Your Ref: OWPC24596
Our Ref: LU/297/19/PL 26-09-2019
Please ask for:
Zac Denton

1 No. new dwelling (resubmission following LU/84/19/PL).

Land to rear of 141 Wick Street Littlehampton

Thank you for your internet representation made on 14th October 2019 which has been recorded as '**an objection**' with the comments as follows:

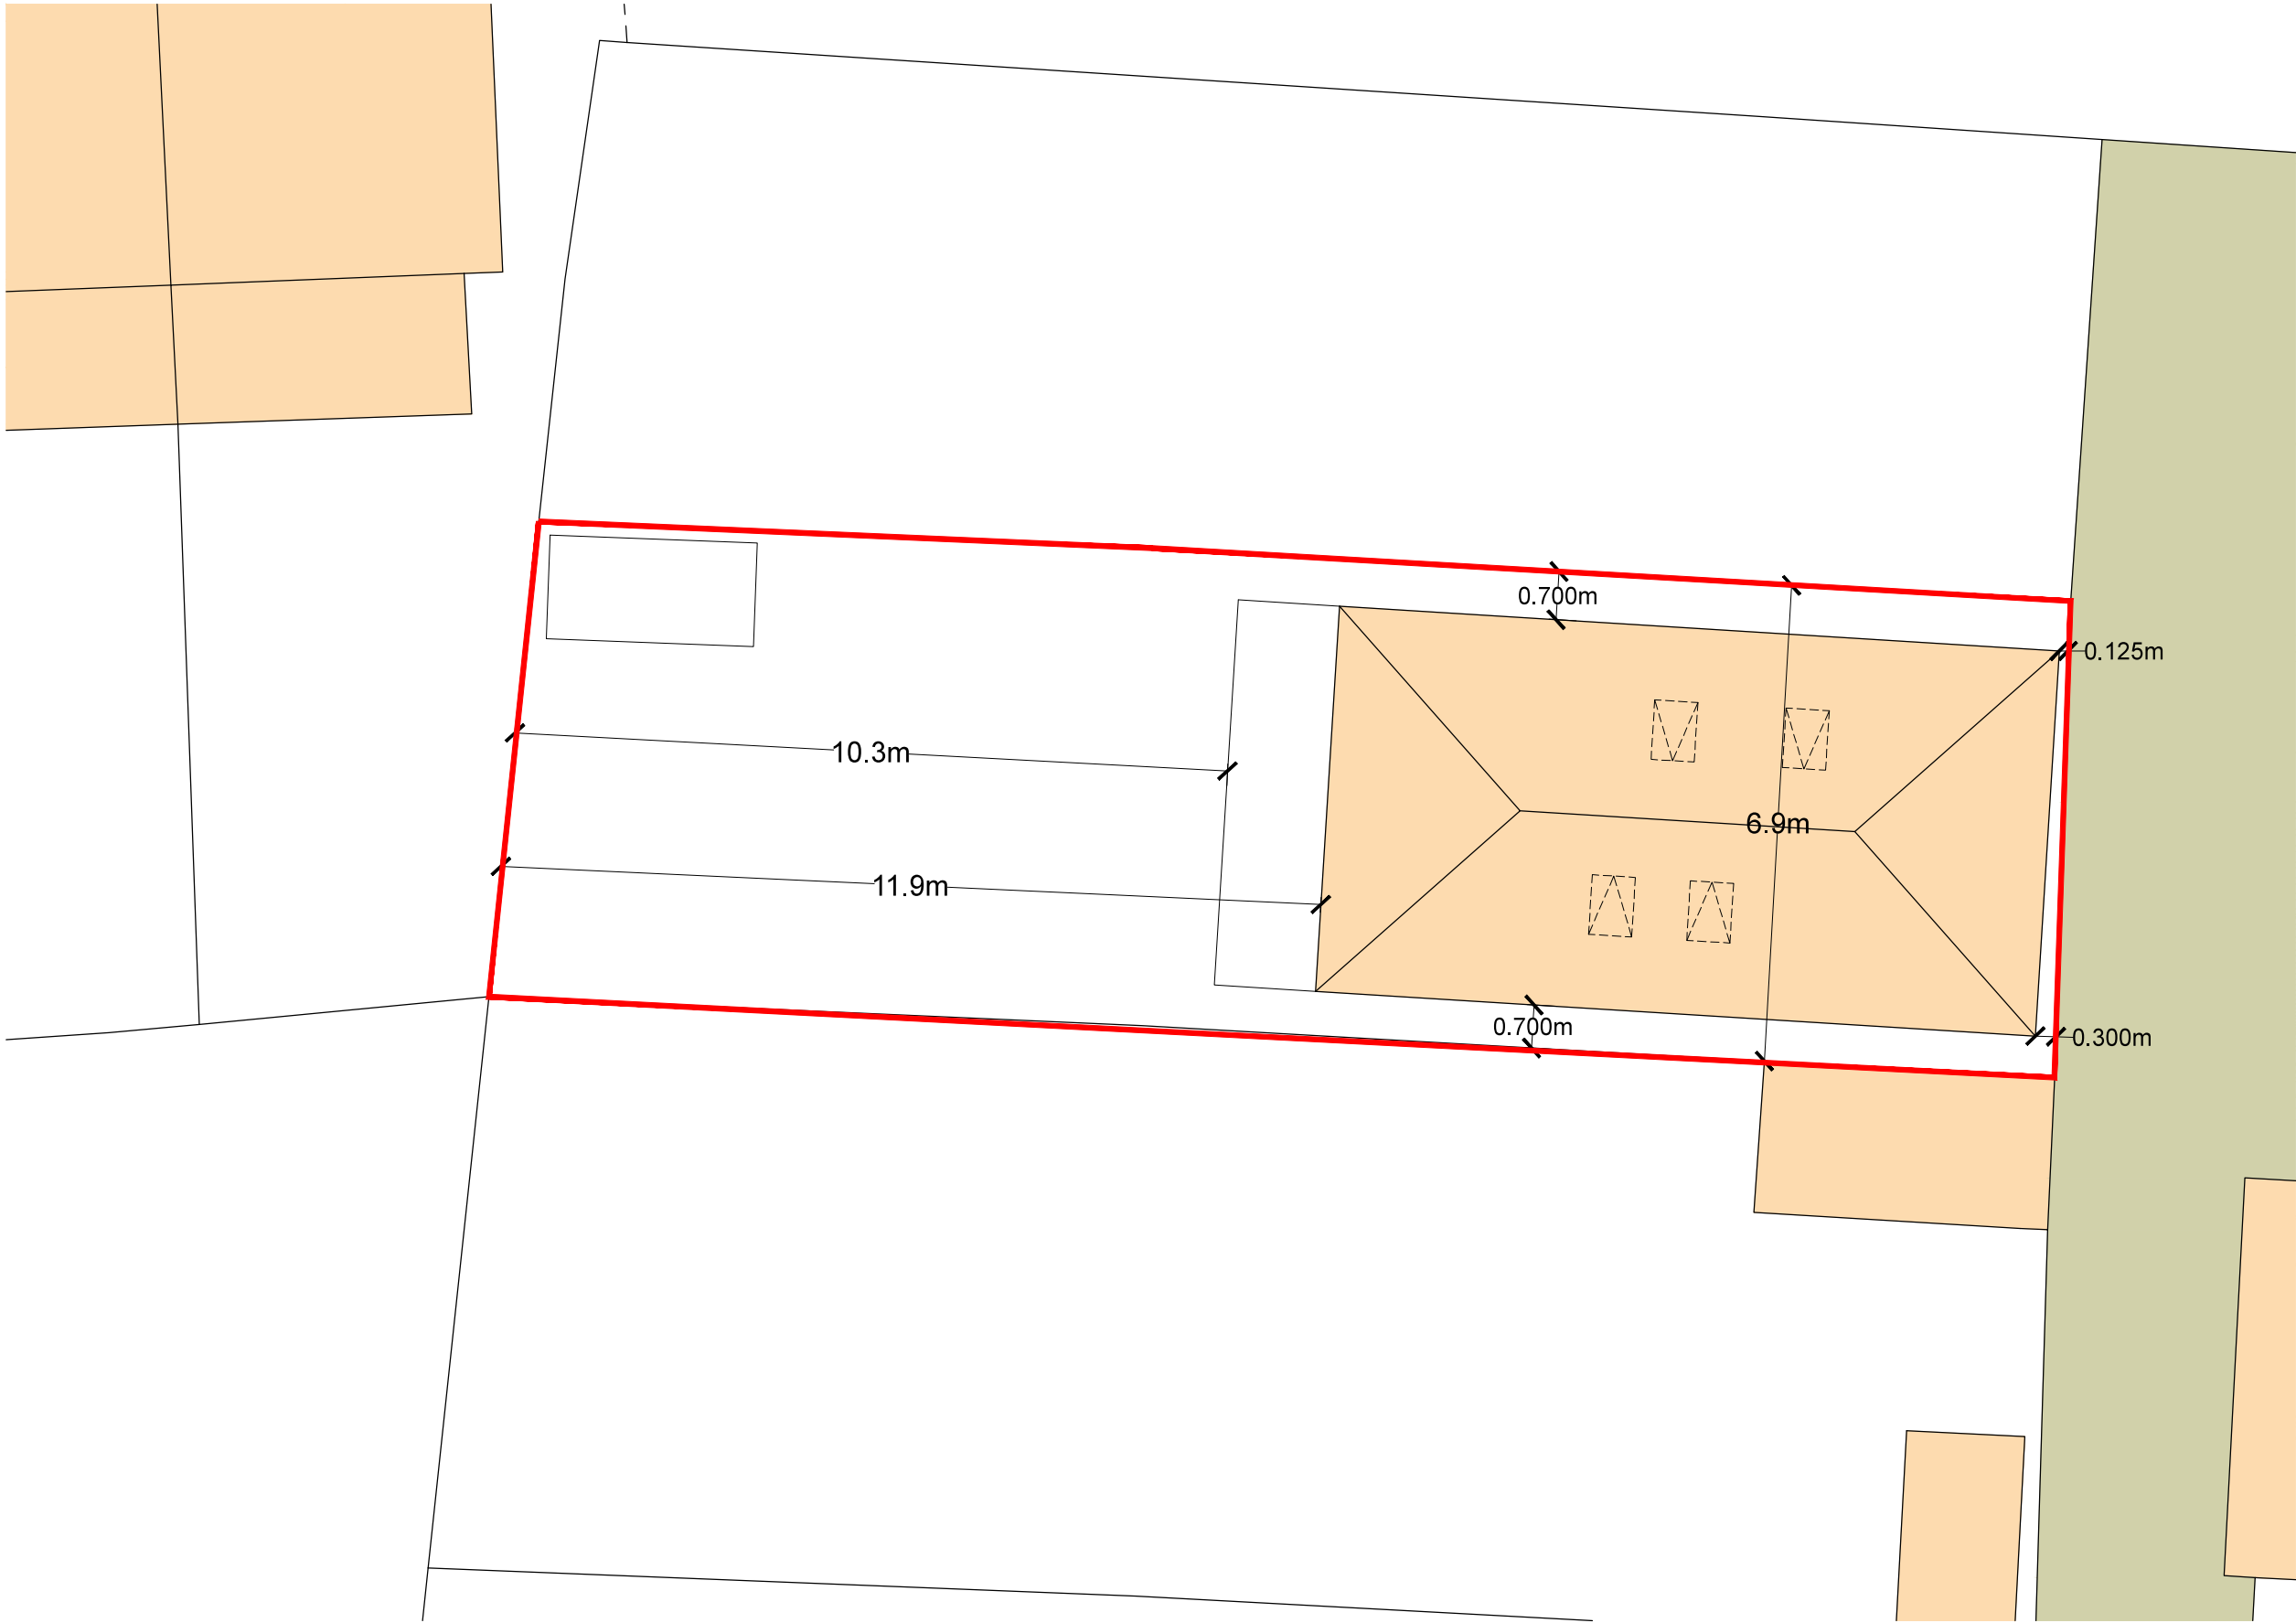
Reading through the WSCC Consultation document, it states, "Fire and refuse access WSCC local mapping and plans show that the minimum width of the access is 2.5m. Consideration at the planning stage needs to therefore be given to emergency access and refuse collection in order to satisfy building regulations".

The minimum width of Access is actually 2.2m, NOT 2.5m as indicated by your 'desktop study'.
